**A30 Chiverton to Carland Cross – Full Written Representation of Cornwall Countryside Access Forum to The Planning Inspectorate**  
**13<sup>th</sup> February 2019**

**GENERALLY:** This representation is made on behalf of **Cornwall Countryside Access Forum**, and amplifies the points made in our initial summary Written Representation made on 7<sup>th</sup> November 2018.

Drawing Title: RIGHTS OF WAY AND ACCESS PLANS APFP REGULATIONS 5(2)(K) SHEET 4 OF 8

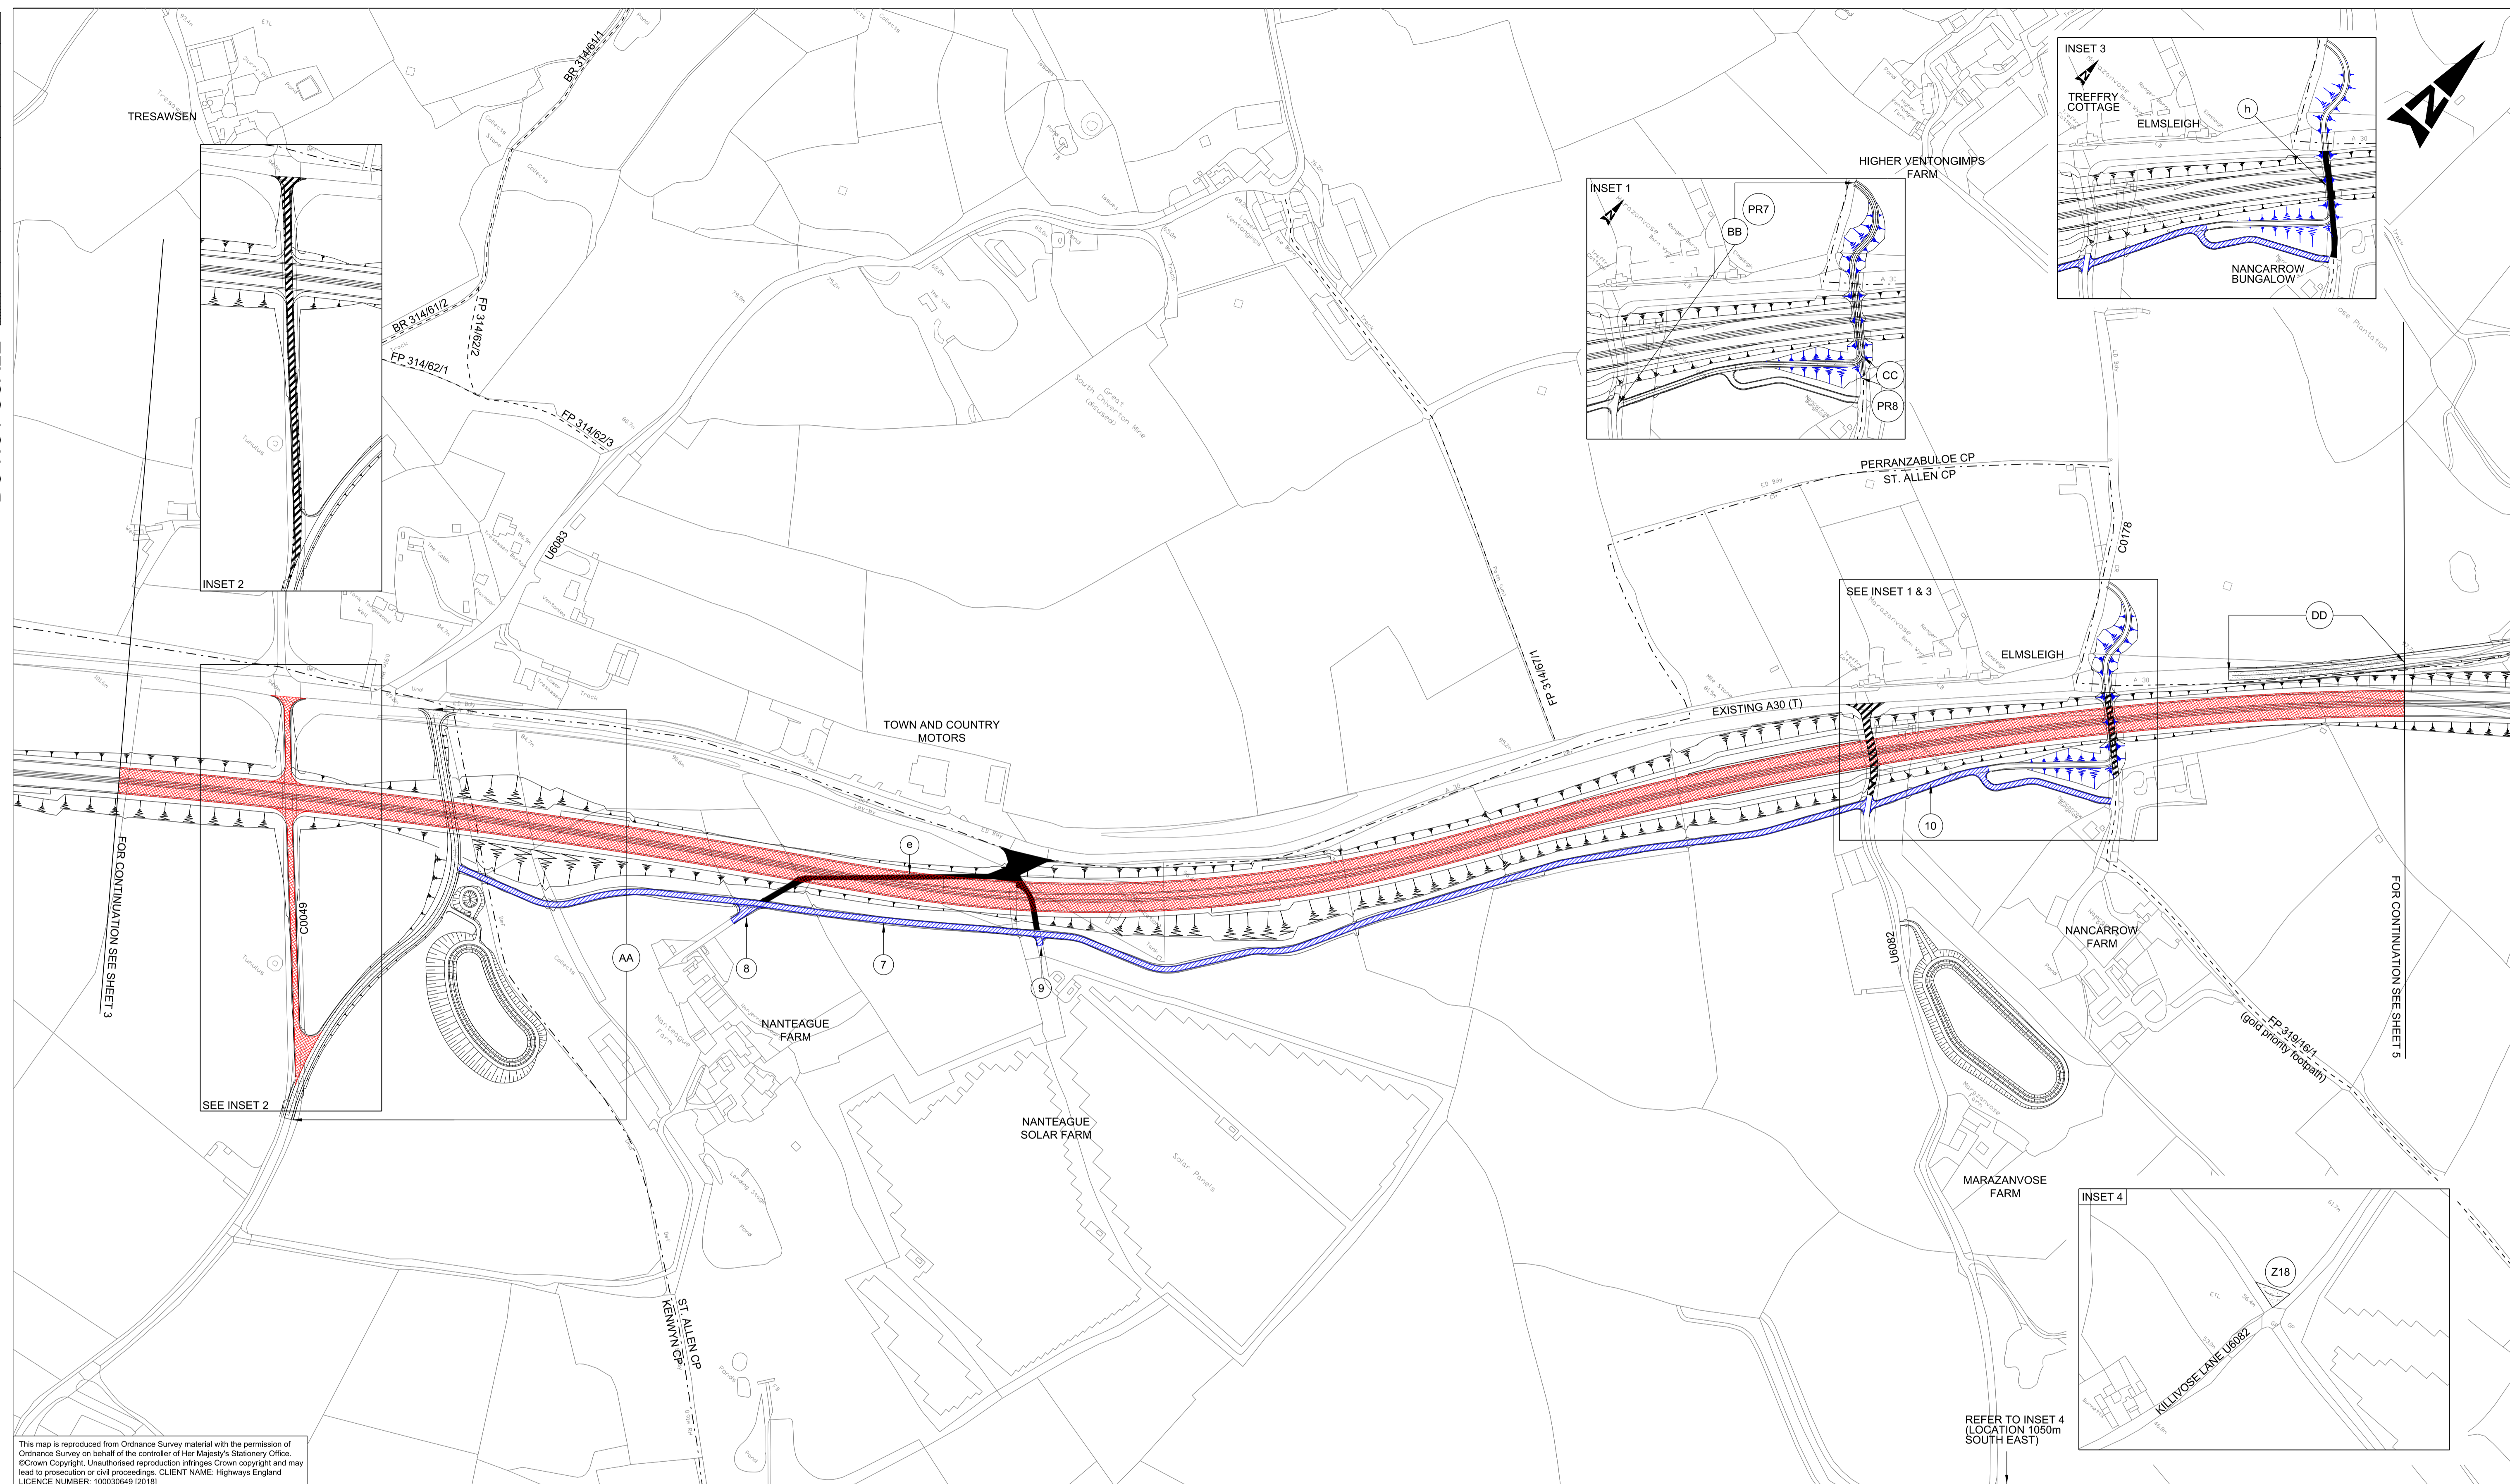
4. **EXISTING TWO BURROWS UNDERBRIDGE:** Noting the stopping-up of the northern arm of the Shortlanesend – Two Burrows road, north of the old A30, (C0080 & part NCR 32), we advise that this short length of road should be retained past St Frieda’s and re-designated as a bridleway to provide an alternative link back to Zelah village, taking WCH away from the new road junction at Chyverton Lodge. The under bridge already provides part of the infrastructure necessary, and links to the Bridleway/Restricted Byways east to Hillhead/ Zelah Lane Farm and West to Costislost to Zelah Lane Farm. (recently approved by the Secretary of State under DMMO).

5. **CHURCH LANE, ZELAH (PR11):** We question the position and alignment of the new WCH underpass Church Lane/U6083, which links U6083 to Church Lane north of the A30 via the old A30 stepped crossing. We submit that this fails to provide a proper link, particularly as it is to be designated as a bridleway, and does not fully restore the Church Lane/U6083 route to its former use or utility. The existing crossing of the old A30, which entails the use of a lengthy concrete stairway either side of the high road embankment, would remain inaccessible and impractical to both cyclists and horse riders. To make equitable (and safe) provision for all WCH users, the new link needs to be on the line of U6083 with provision of an underpass under both the new and old A30 roads to take all WCH users into the heart of the village. The present proposal is inadequate for its stated purpose.

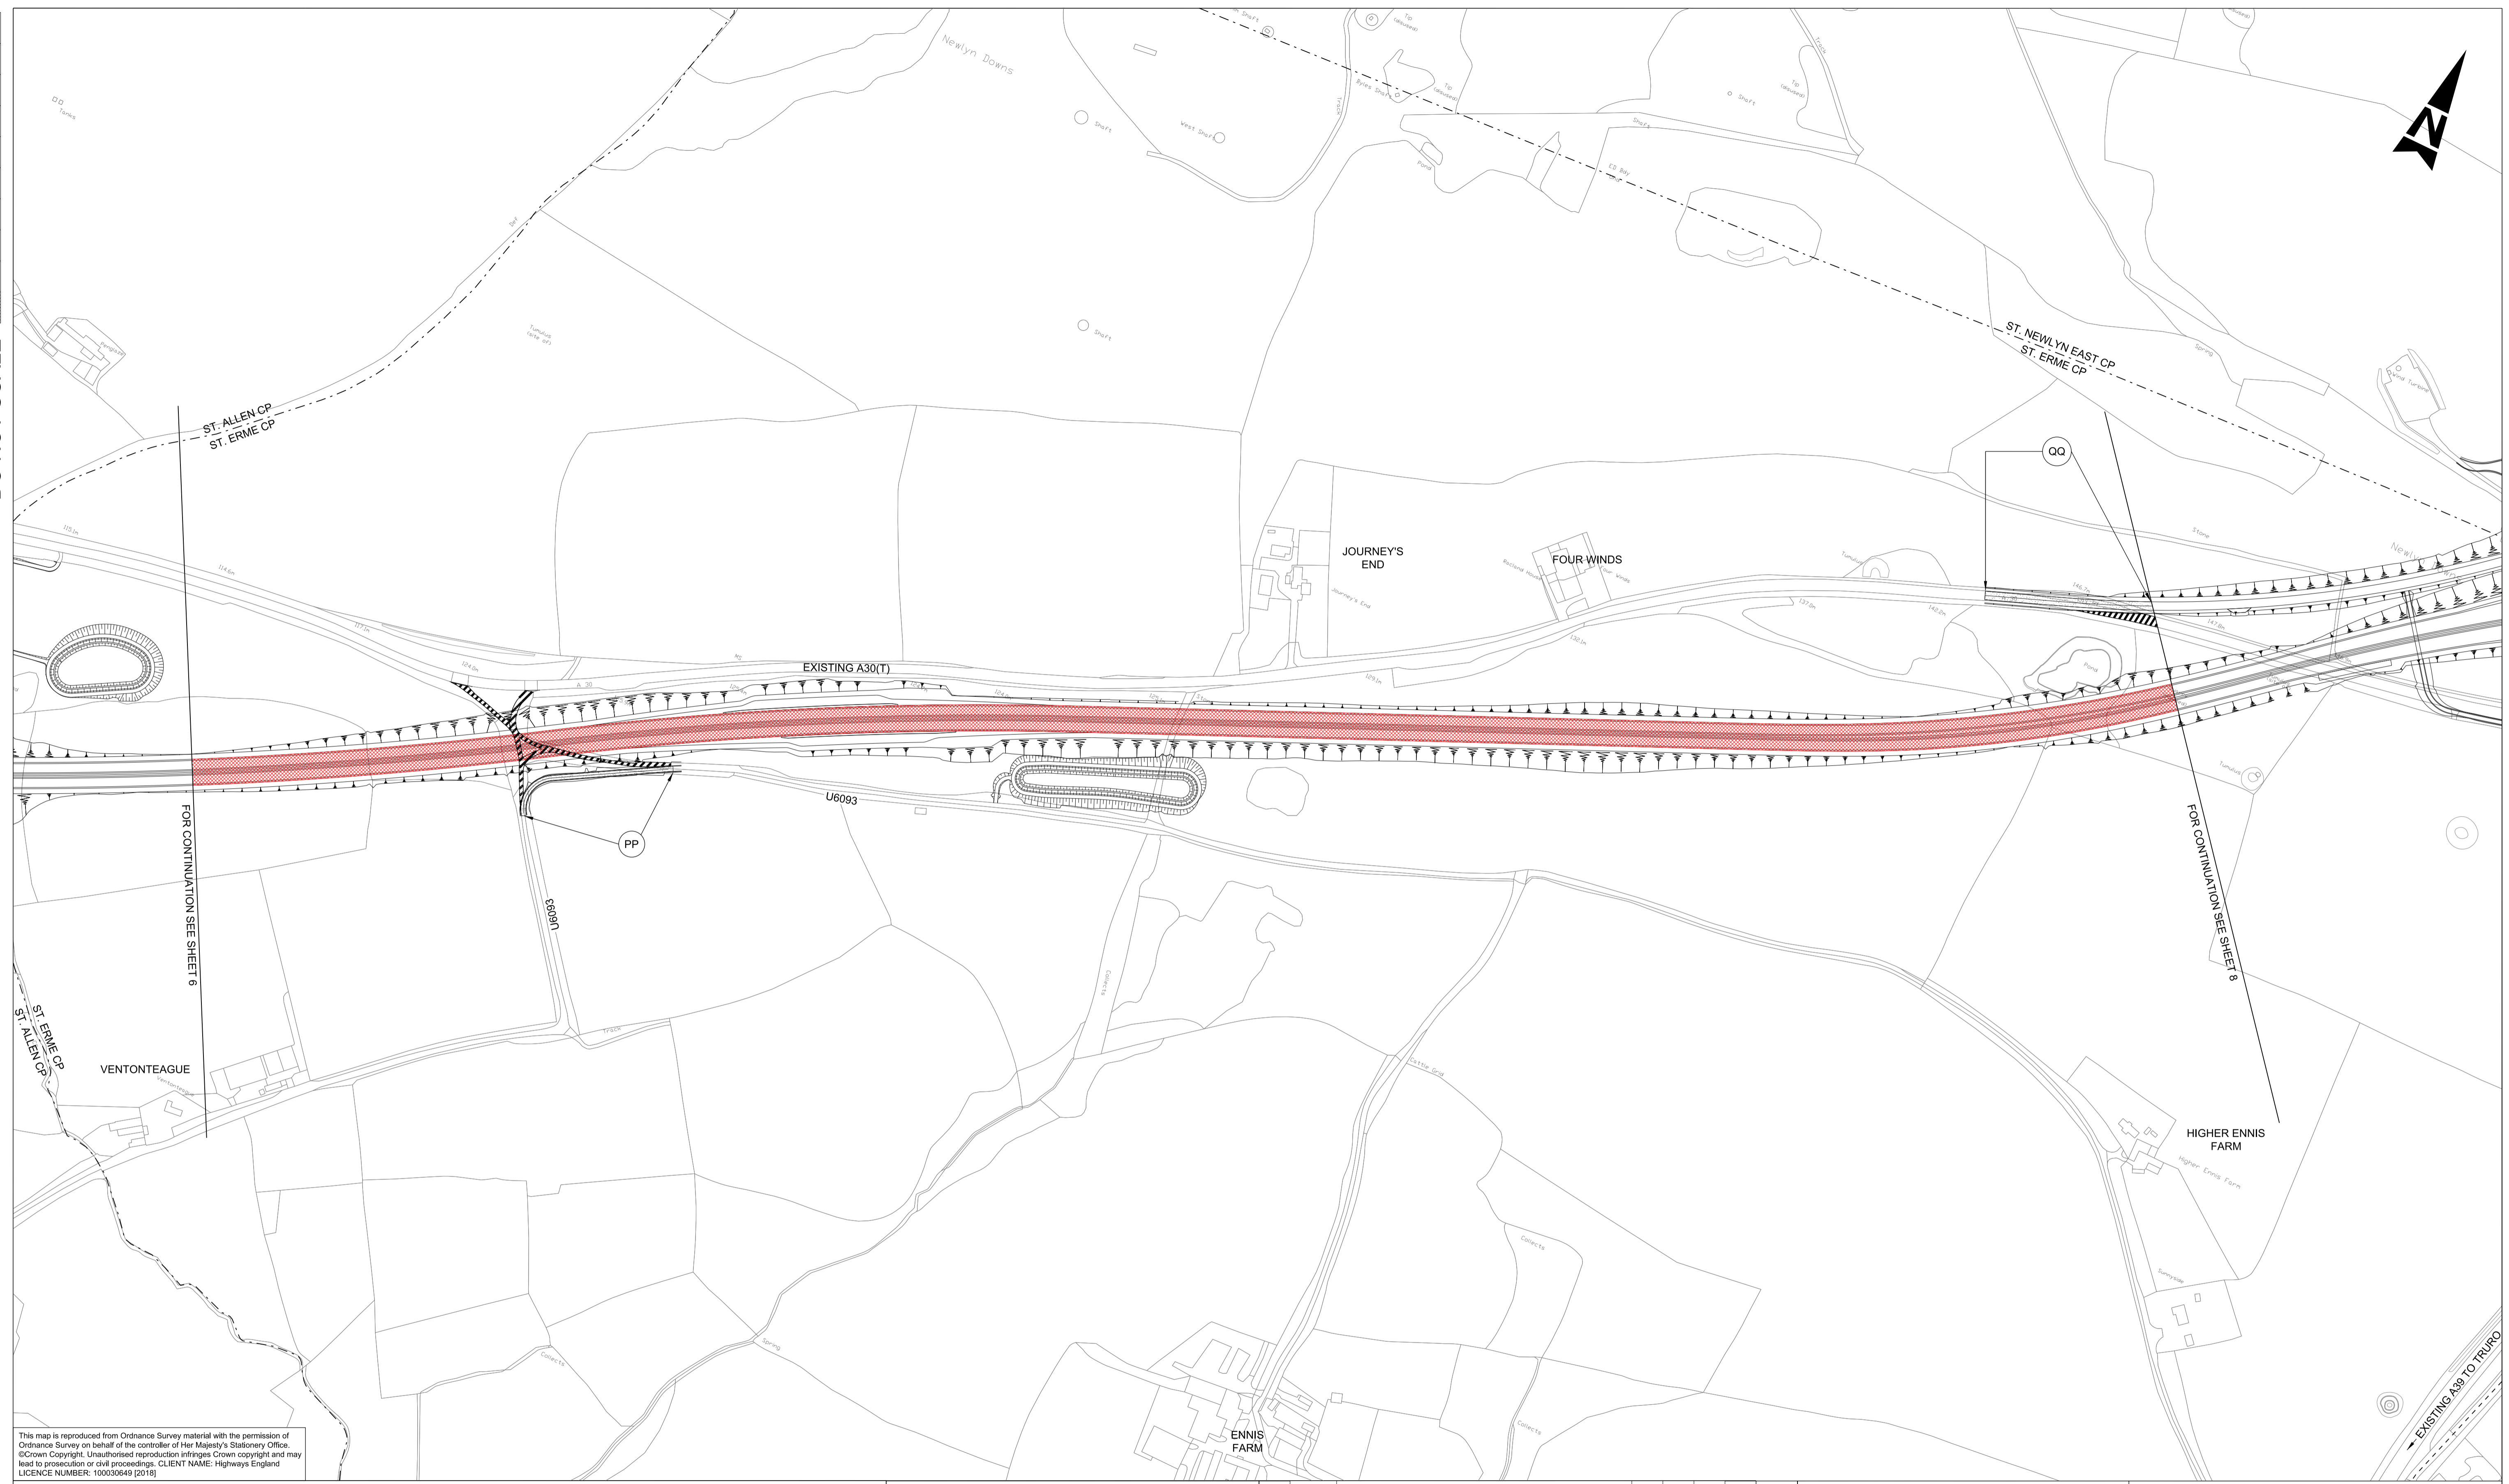
6. **CARLAND CROSS:**
    - a. The Forum particularly welcomes the propose WCH link (PR14) using the old A30 route and the new underpass to maintain north – south connectivity. We also welcome the proposed WCH link (PR15) to Mitchell using the original A30 road.

- b. However, we have been told that the crossings for WCH on the southern side of the existing roundabout (A39), (linking PR14 to PR15) will remain as at-grade crossings, utilising the refuge island for crossing between the two-lane northbound and two

lane southbound traffic. This will involve WCH crossing four lanes of traffic, at a busy junction (particularly busy at rush-hours) which we consider to be potentially dangerous. Consequently, we advise that consideration to be given to providing controlled crossings (possibly Pegasus crossings) on the existing footway to form a continuous safe WCH route from Mitchell to the old A30.

7. **MITCHELL:** Signage provision for westbound cyclists on the existing dualled A30 coming from East Cornwall – we are again concerned on both grounds of safety and convenience that adequate signage provision is made to direct westbound cyclists, particularly “End to Enders”, off the new A30 and onto the de-trunked old A30 via Mitchel and Carland Cross.
